Report on Objections to Part 10 Development (ACP-323950-25)

Graiguenamanagh Tinnahinch Flood Relief Scheme

Report No. W3451-W-R021

Kilkenny County Council

Date: 31.07.24	Scale: 1:1000	Drawn: LT	Chk: SH	App: SH
Project No: W3451	Drg. No: W3451-AYE-DWG-W-1404	Rev:

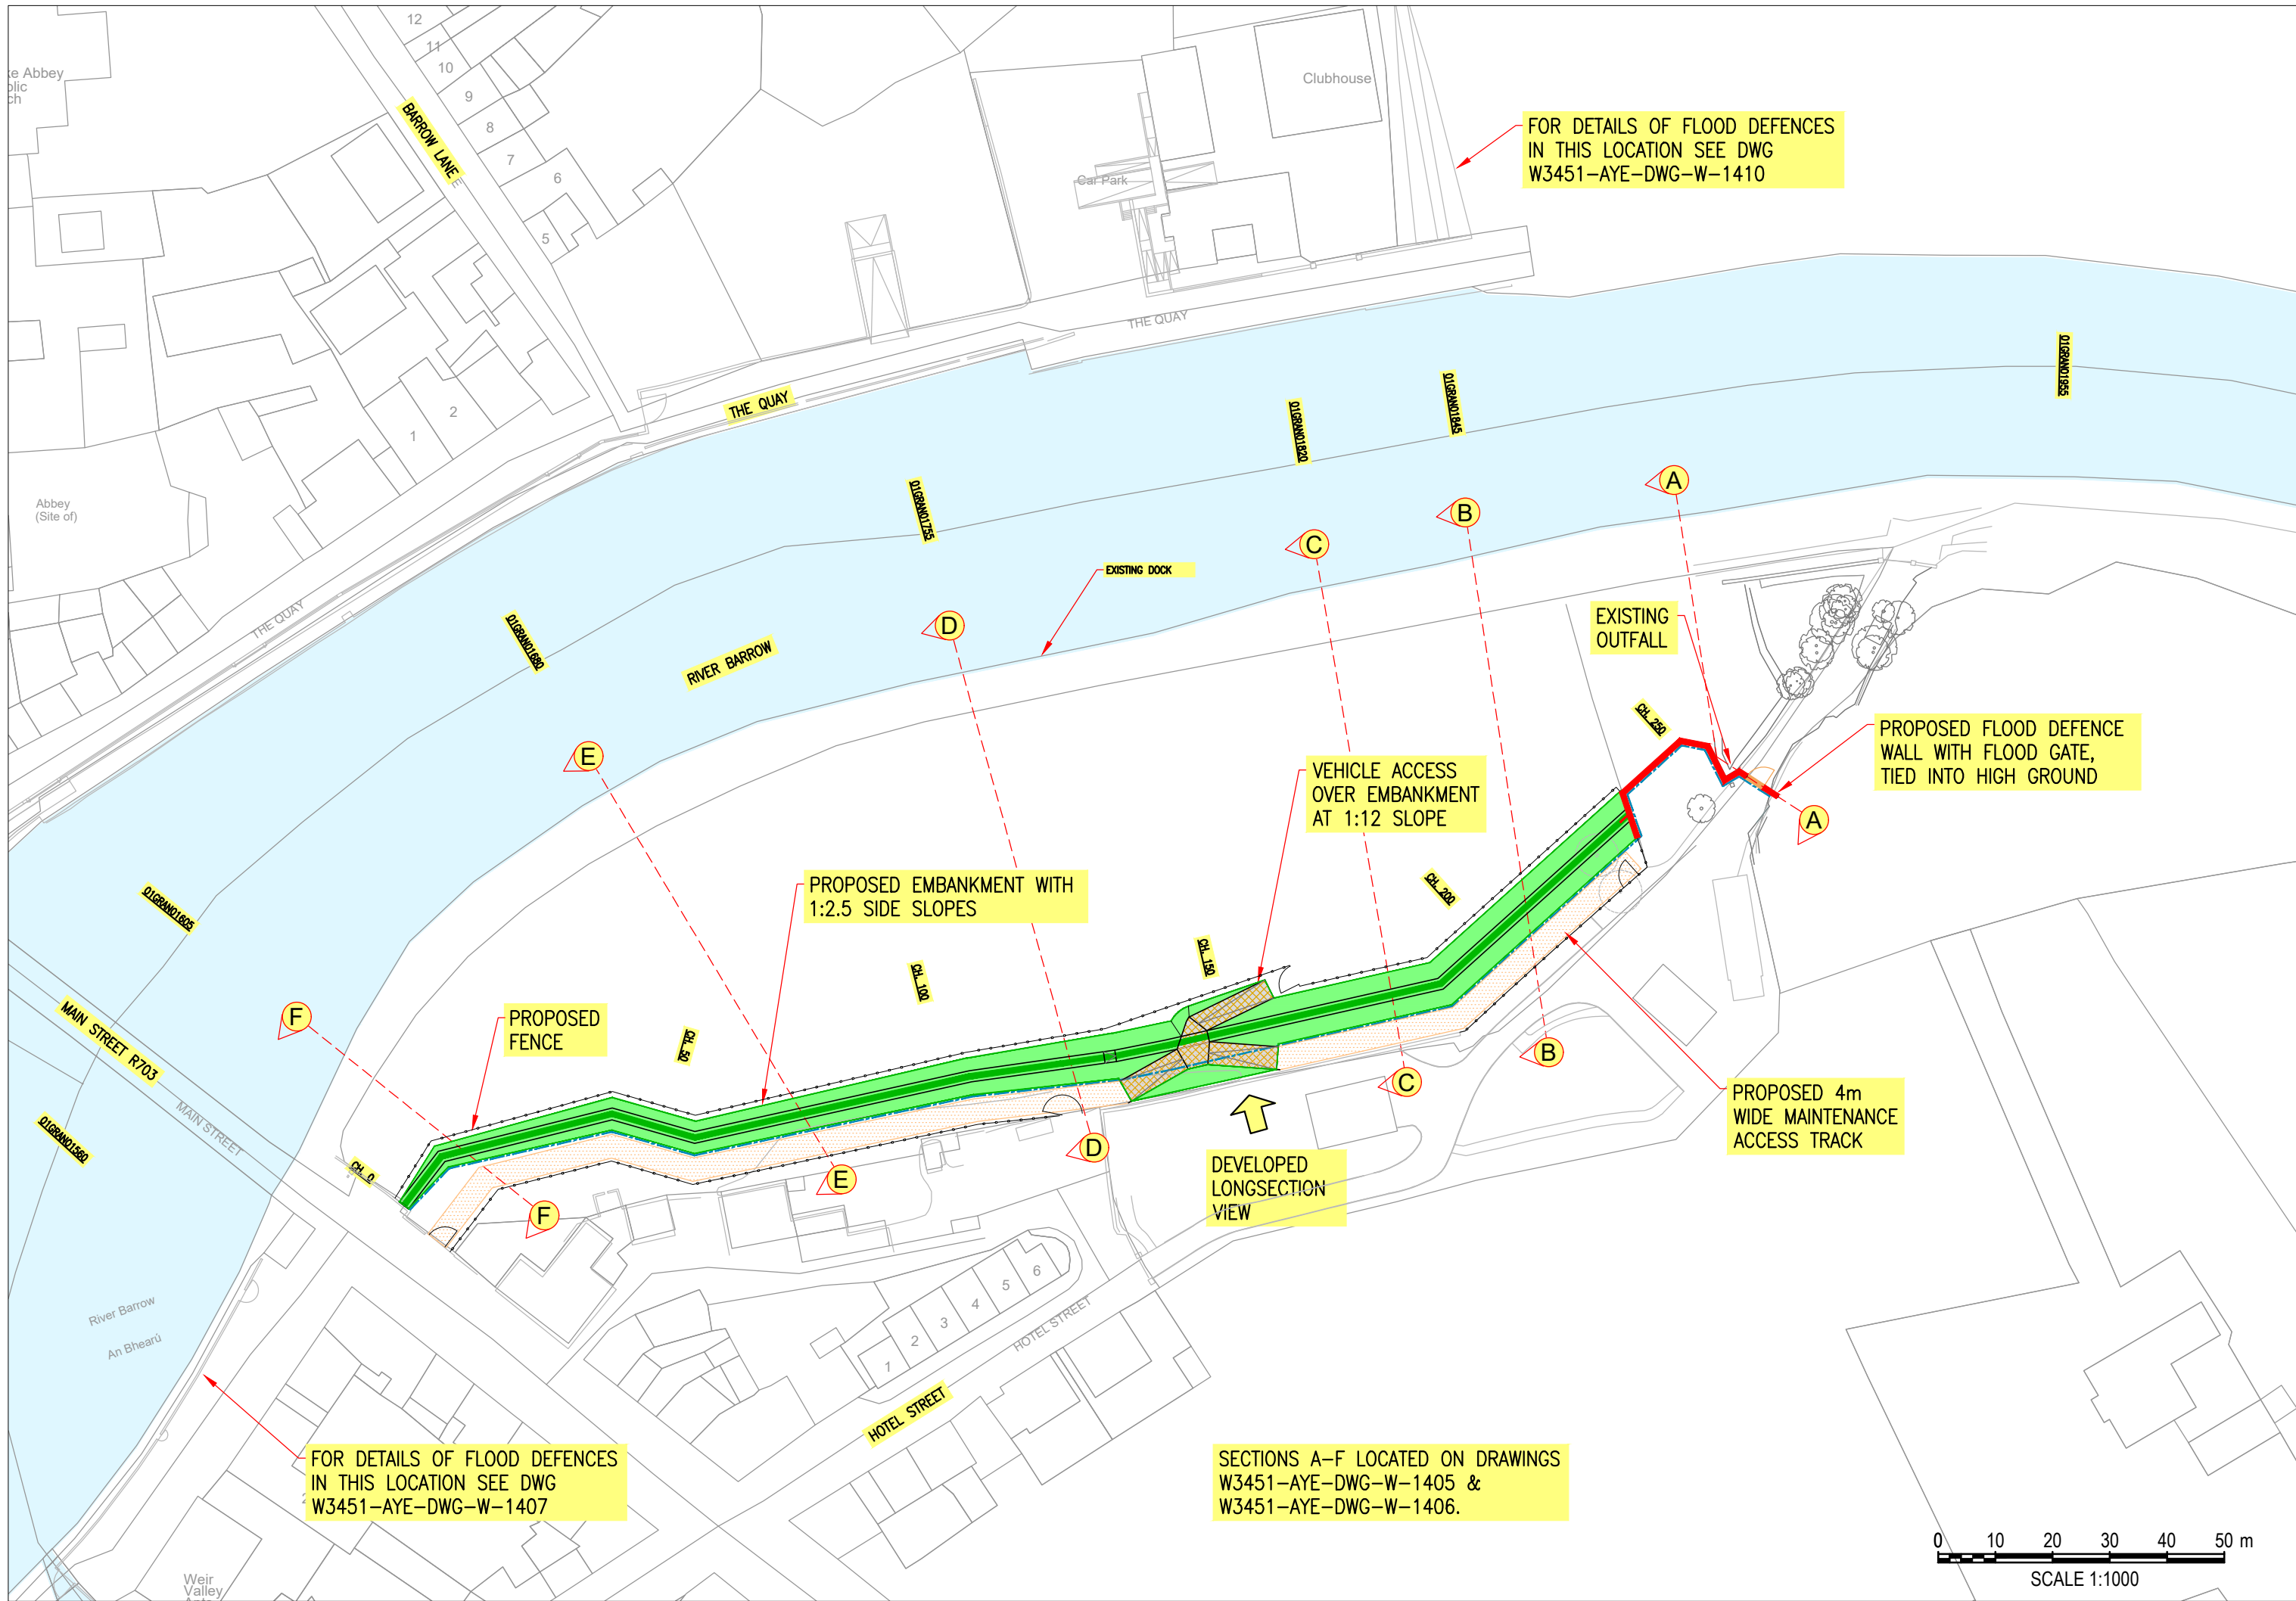
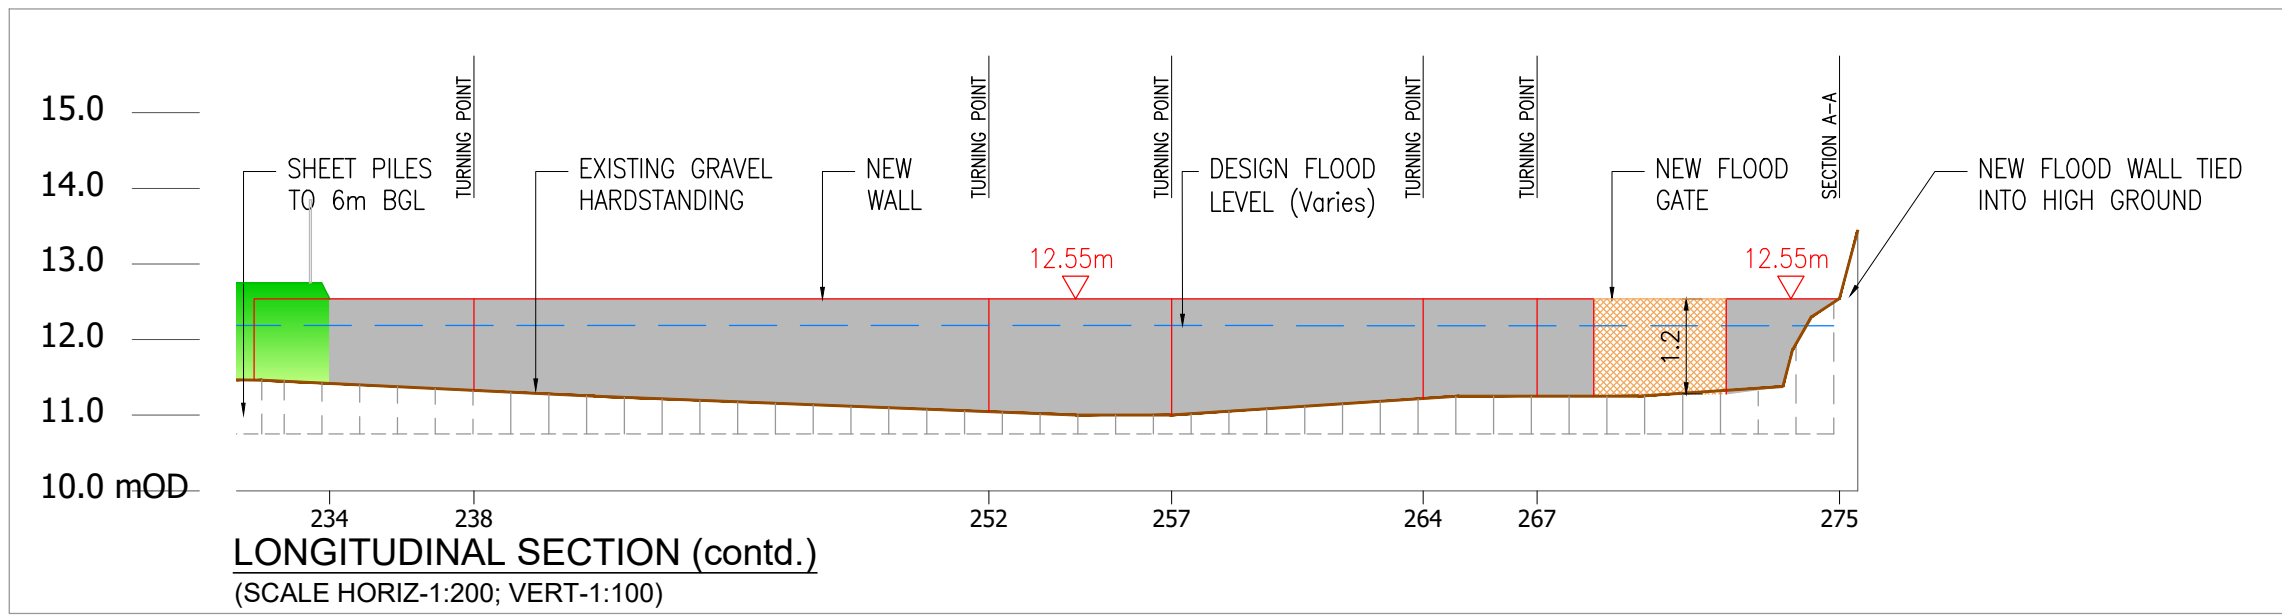
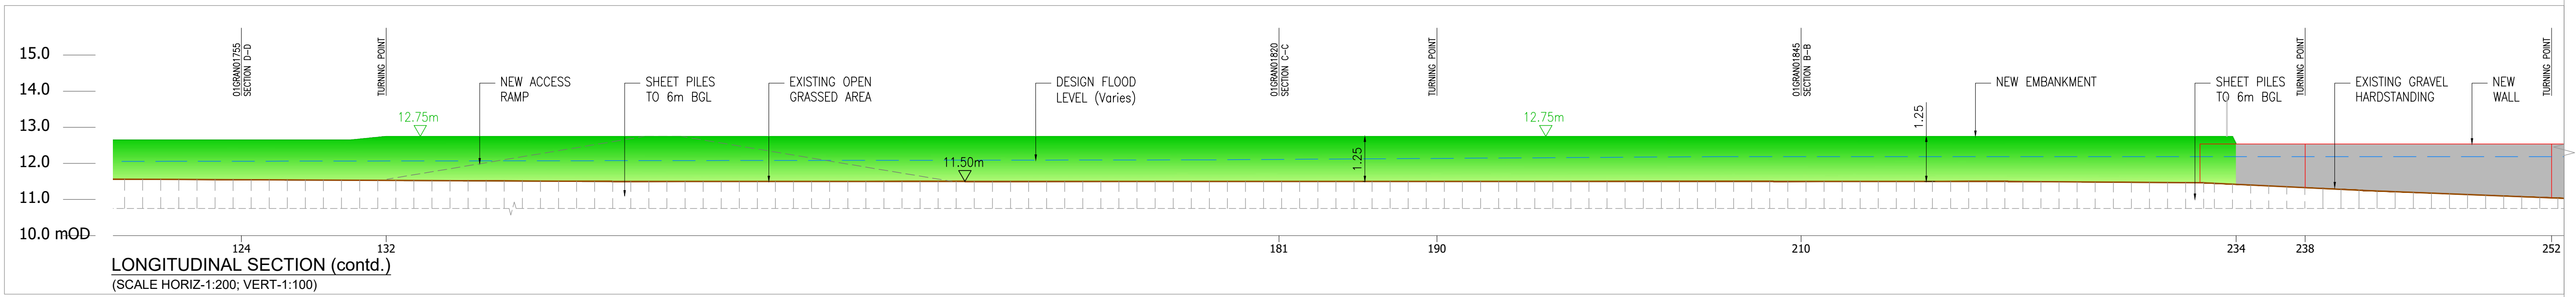
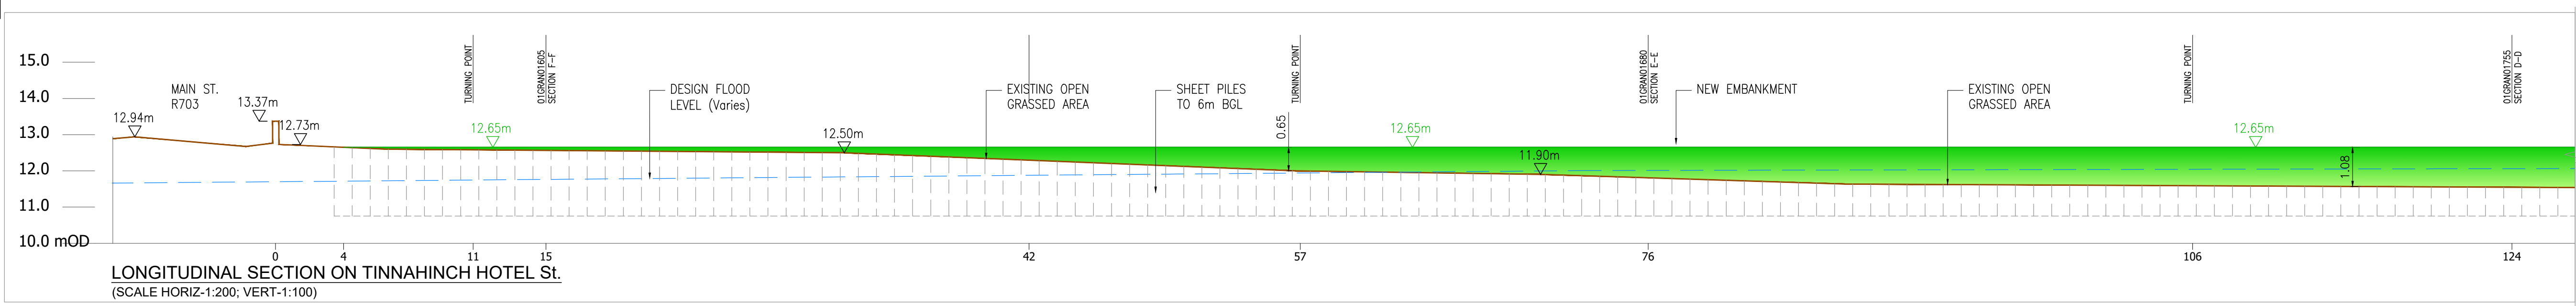
[7.2] Impediment to the Use of Private Property and Obstruction of Views

The proposed flood measures adjacent to the rear patio and garden of the subject property are quite low. At this particular point, and as the Walsh's have identified elsewhere, the 1% AEP flood level does not actually reach the location of the embankment. The embankment has been aligned to reach ground with sufficient freeboard to address the inherent and unavoidable uncertainties of flood level estimation. The freeboard for the scheme is 550mm and given the ground is slightly higher than the flood level, this means that the embankment ranges from 0m high to 500mm high in the vicinity of the Walsh's.

Whilst it is acknowledged that the views will be impacted, the scale of the impact is considered to be very limited impact on views from the property and patio.

KCC are aware of two main access routes for vehicles/machinery to the lands, both through other lands within the Walsh ownership. It is not proposed to affect these accesses, and provision has been made for access over the embankment at the eastern most access (Access 2) as per the planning drawings. This is for the Walsh’s benefit. KCC are open to sharing Access A also if the landowners desires. Figure 7.5 **Error! Reference source not found.** below outlines the layout plan whilst Figure 7.6 shows the current arrangements.
